## Maine Craft Distilling

Thanks for this information, I have some additional comments about using the original shell plans for this fit up permit:

A1-2

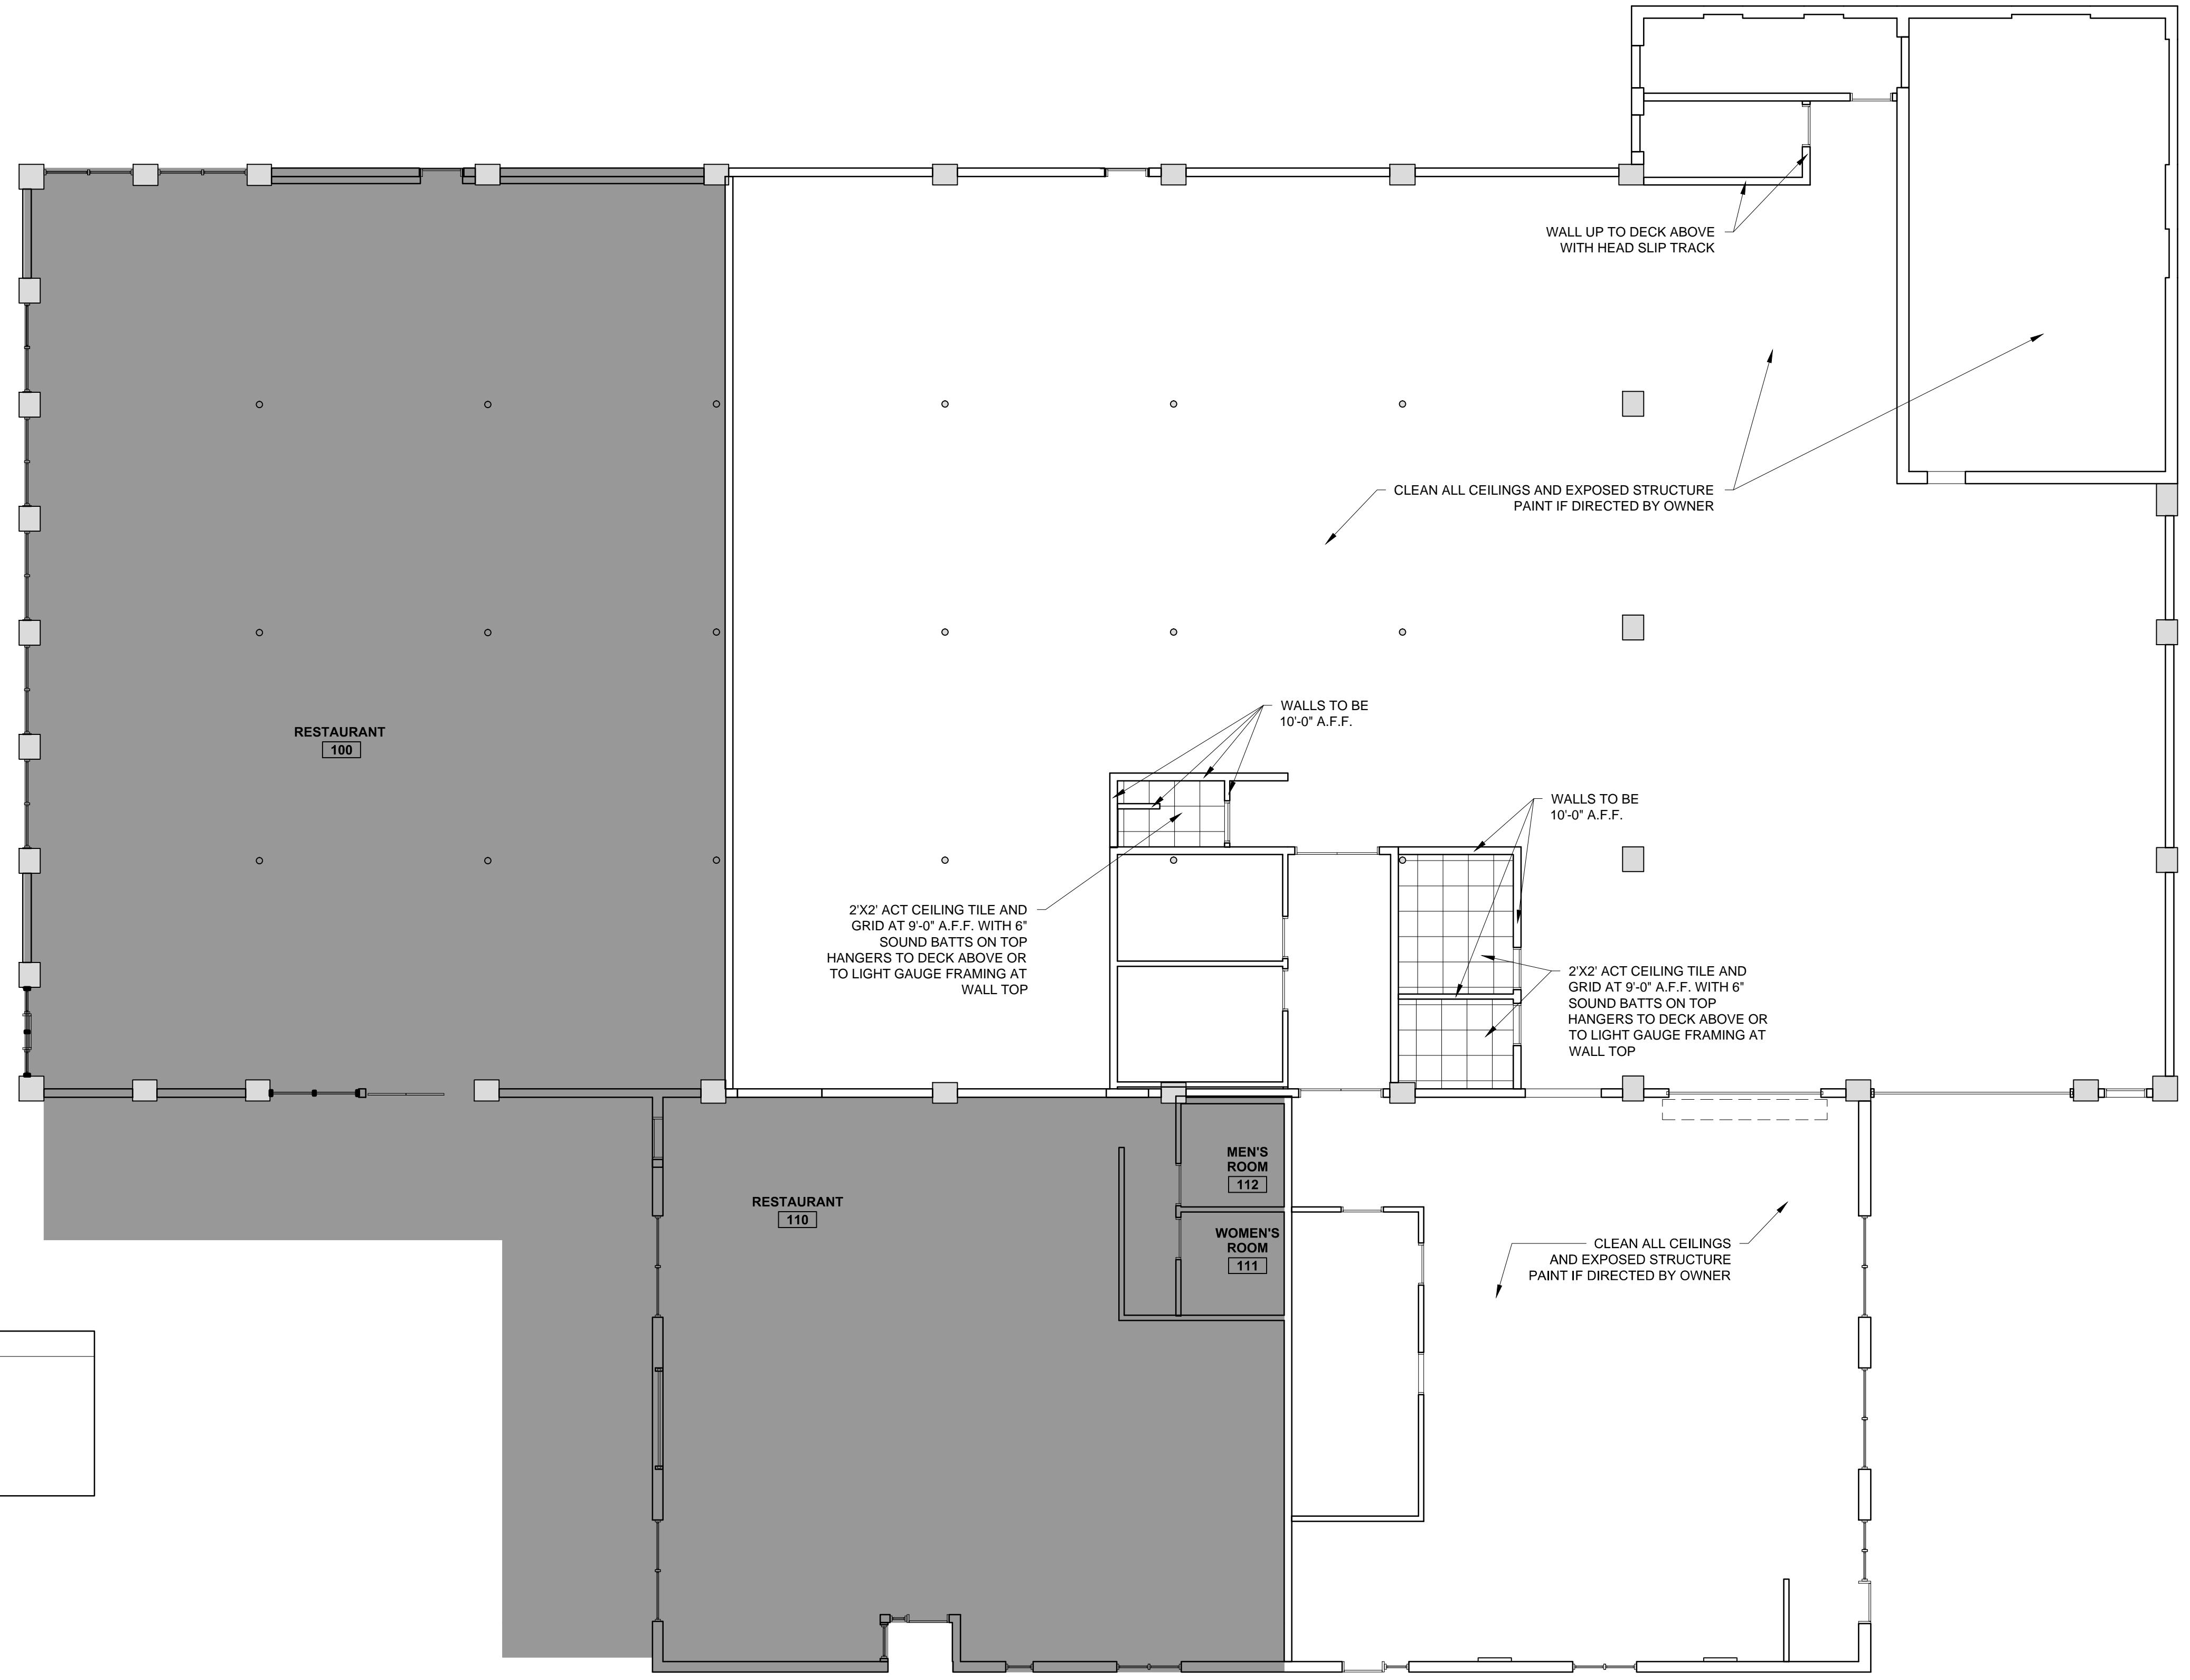
1. The overlapping information is not consistent, please submit the plan details as requested for this project. For instance, the shell plan for A1-1 reflected ceiling plan does not provide the information specific to this fit up area.
2. Please do the same for sheet A1-0, the shell plan calls out a wall type 1B which is not listed on this fit up plan sheet A0-1 wall type. Rated door 124.1 is also not listed on this fit up sheet A7-0 door and window schedule.
3. The manual was previously submitted for the hopper bin, and in looking at this further and silo spec for a 12' diameter, the concrete depth for 7 rings is 12" for a square footer. Please confirm if this design is adequate for the local soil and frost depth conditions.
